# CITY OF ALBUQUERQUE

December 4, 2018

**RE: Westgate Community Center  
10001 DeVargas Rd SW  
Conceptual Grading and Drainage Plan  
Engineer's Stamp Date: 11/30/18  
Hydrology File: M09D030**

By: JPW Sheet: Of:  
 SITE DEVELOPMENT PLAN C-102

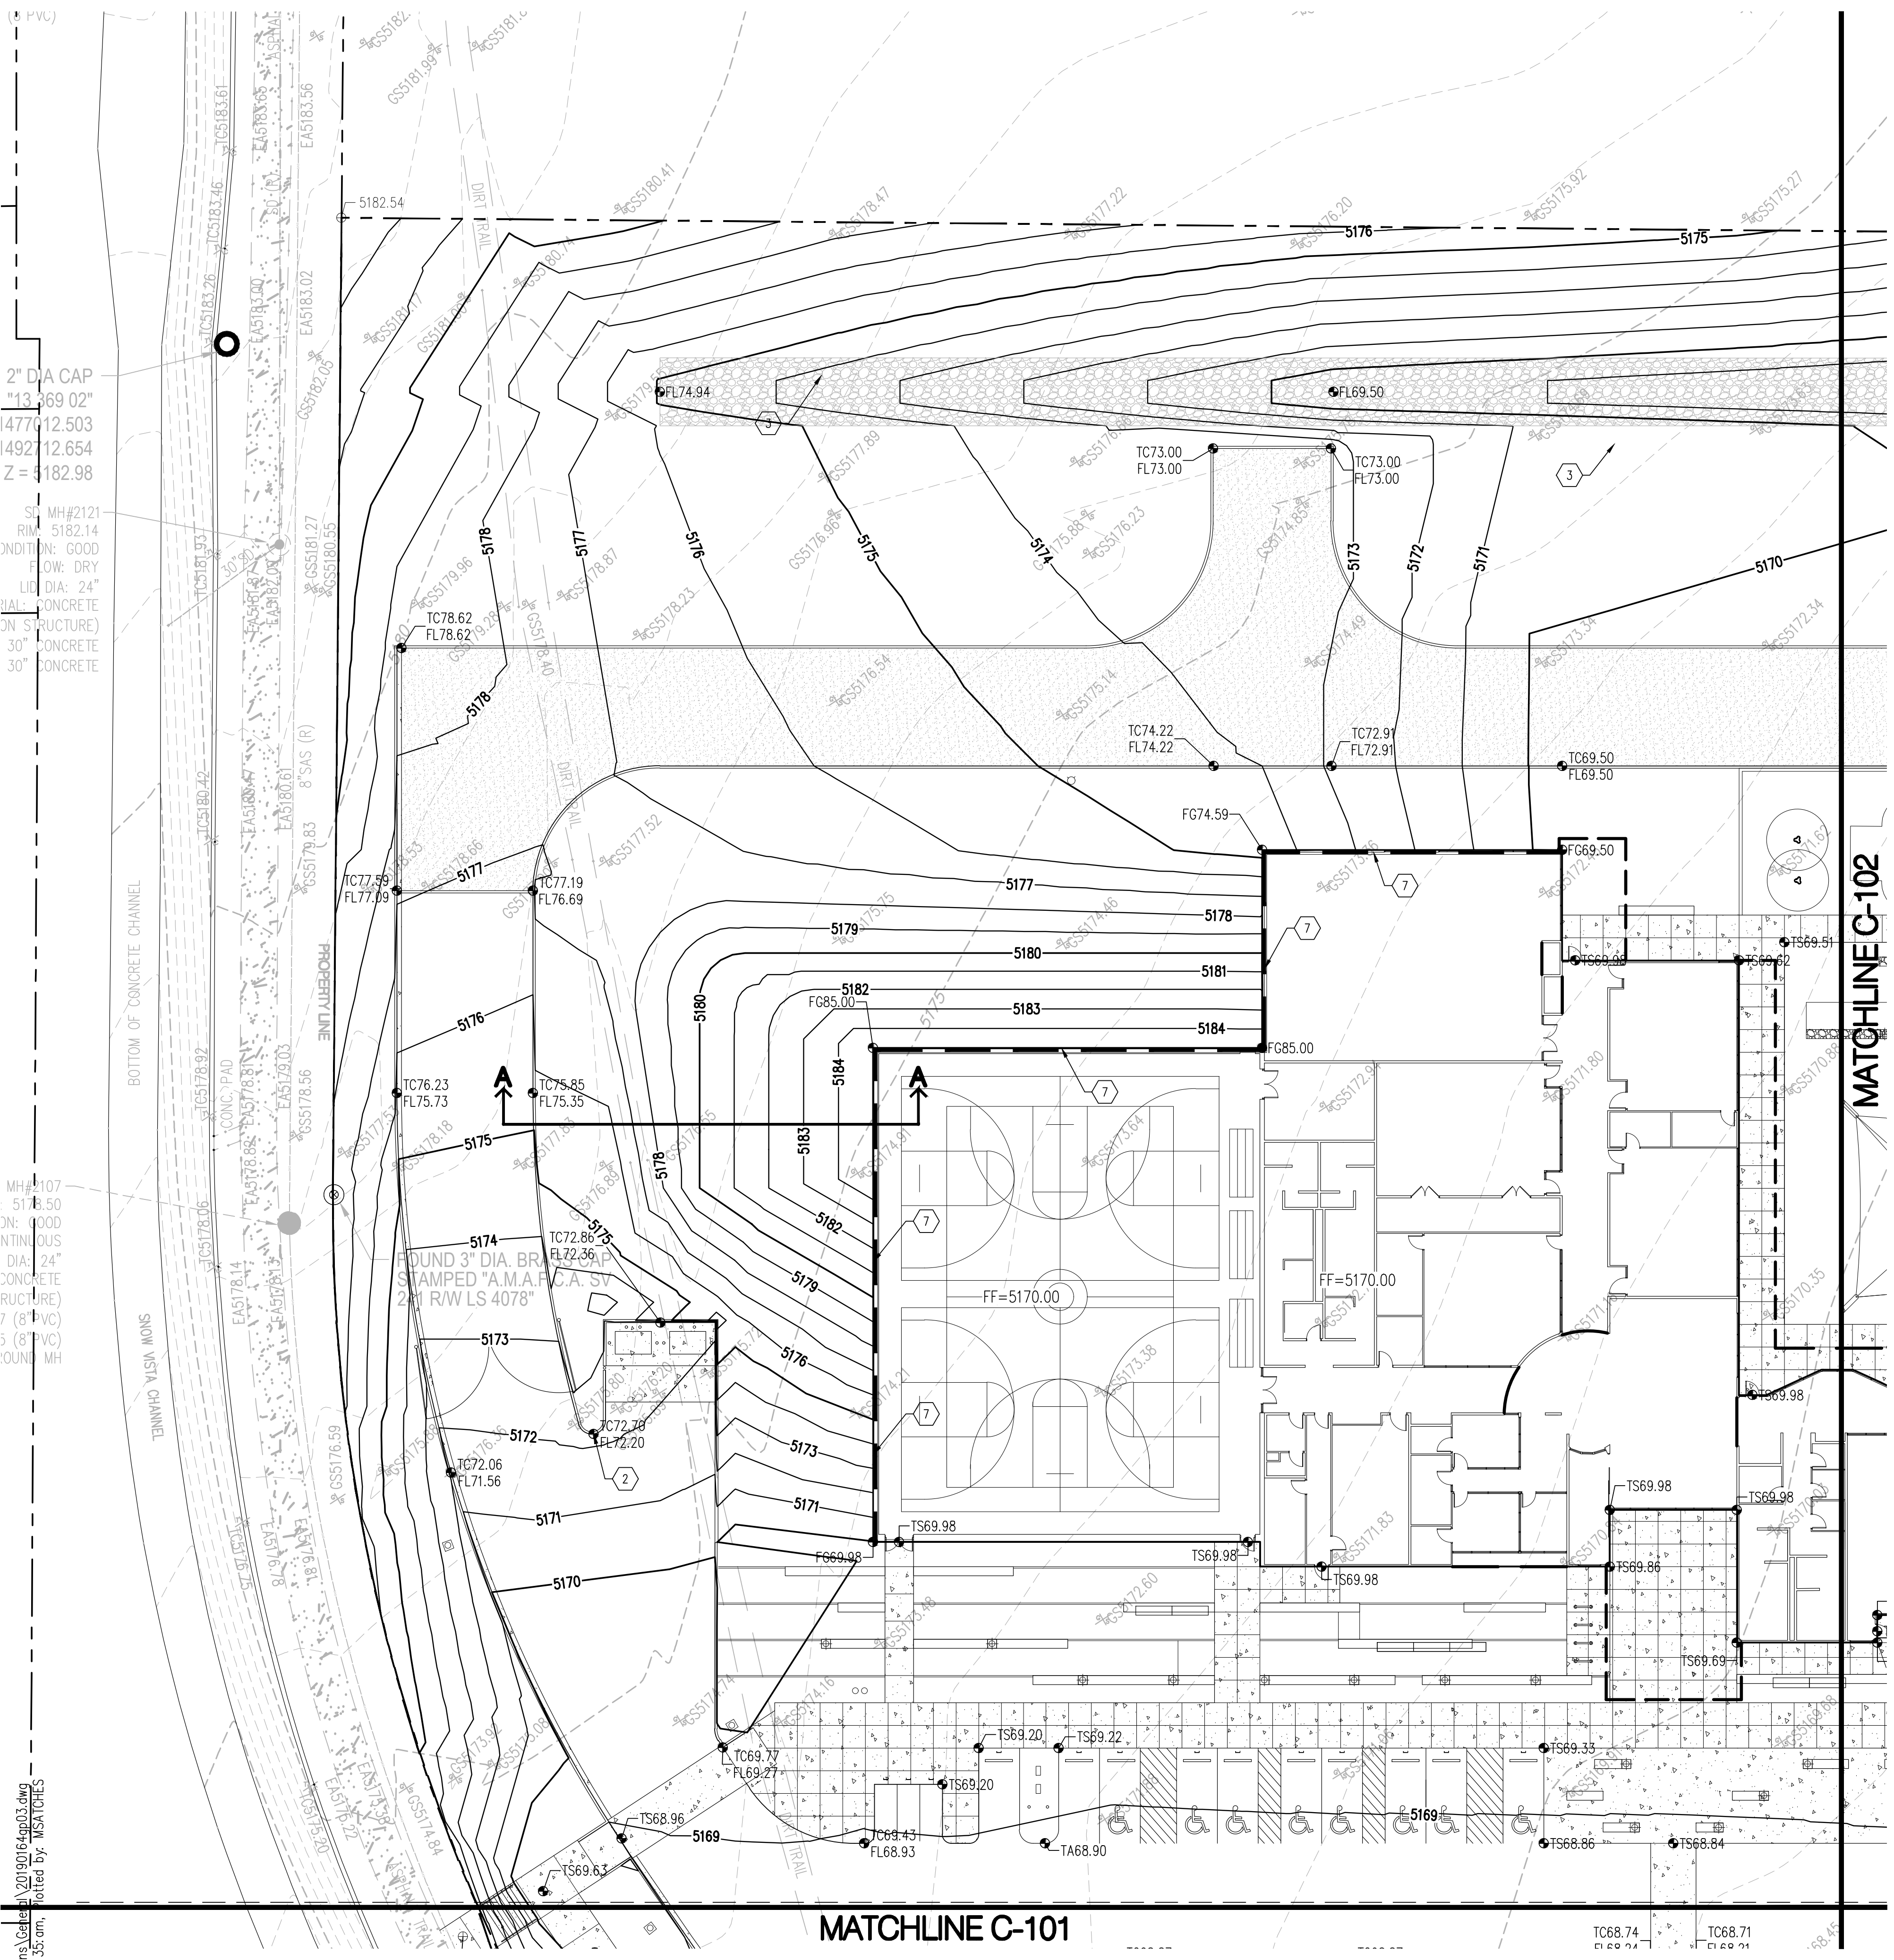
1. Specify Std Dwg 2260 for the ribbon channels.
2. Because Pond 4 retains more than the 100-yr, 10day volume for the contributing area, it doesn't need an emergency spillway (the channel out to DeVargas). This should be removed as it conflicts with the proposed and future built-outs of DeVargas and its sidewalk.
3. Correct the grading around the SE corner of Pond 4, especially the 5160' contour.
